Application No: 6/2023/0297/VAR

Date of Refusal: 4 April 2023

Development: Variation of condition 2 (drawing numbers) on planning permission 6/2021/1144/VAR

At Location: 50 Plough Hill Cuffley Potters Bar EN6 4DS

EXISTING FRONT GATED WALL  
-Variation-

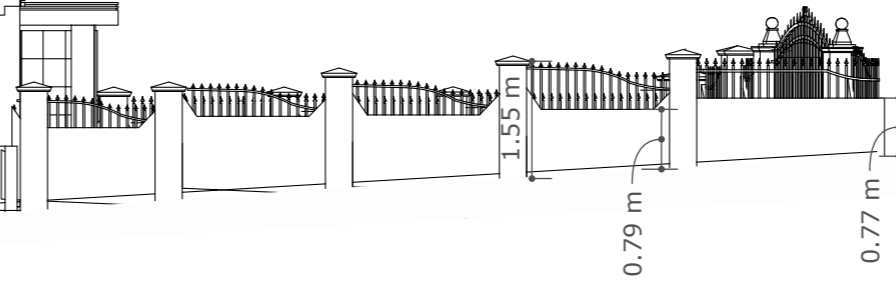
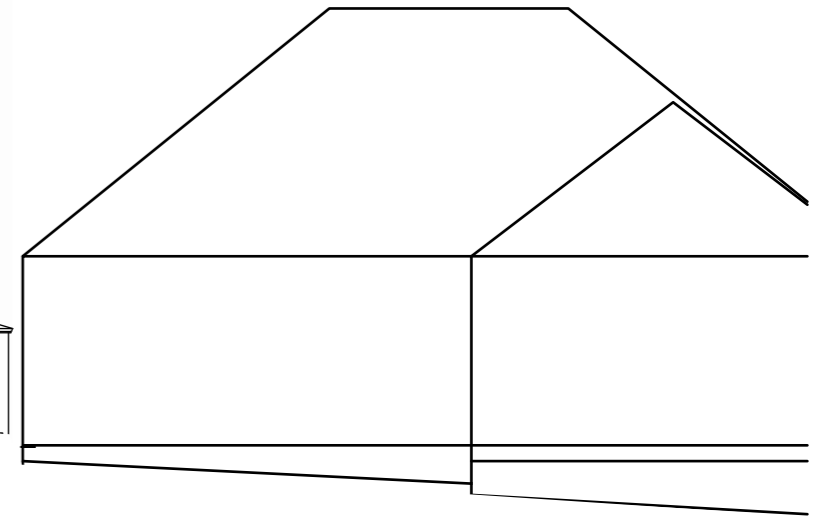
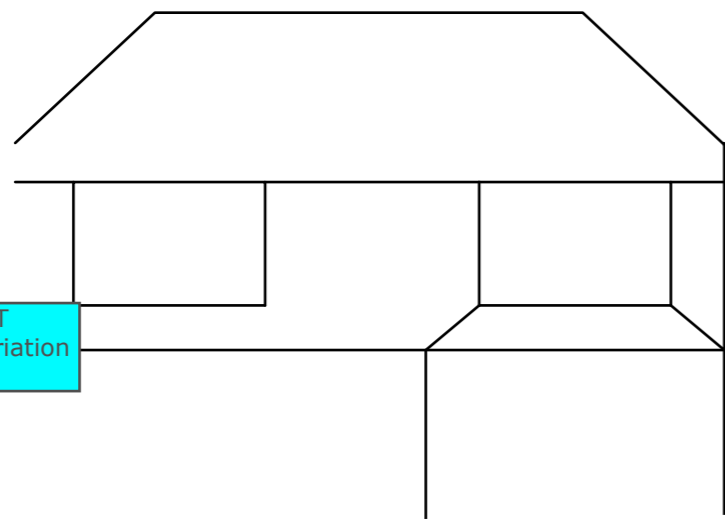
1. The design, height and scale of the implemented boundary treatment detrimentally detracts from the character and appearance of the area, contrary to Policies D1 and D2 of the Welwyn Hatfield District Plan; Policies SADM11 and SP9 of the Welwyn Hatfield Draft Local Plan Proposed Submission (August 2016) Incorporating the Proposed Main Modifications (January 2023); the Supplementary Design Guidance; and the National Planning Policy Framework.
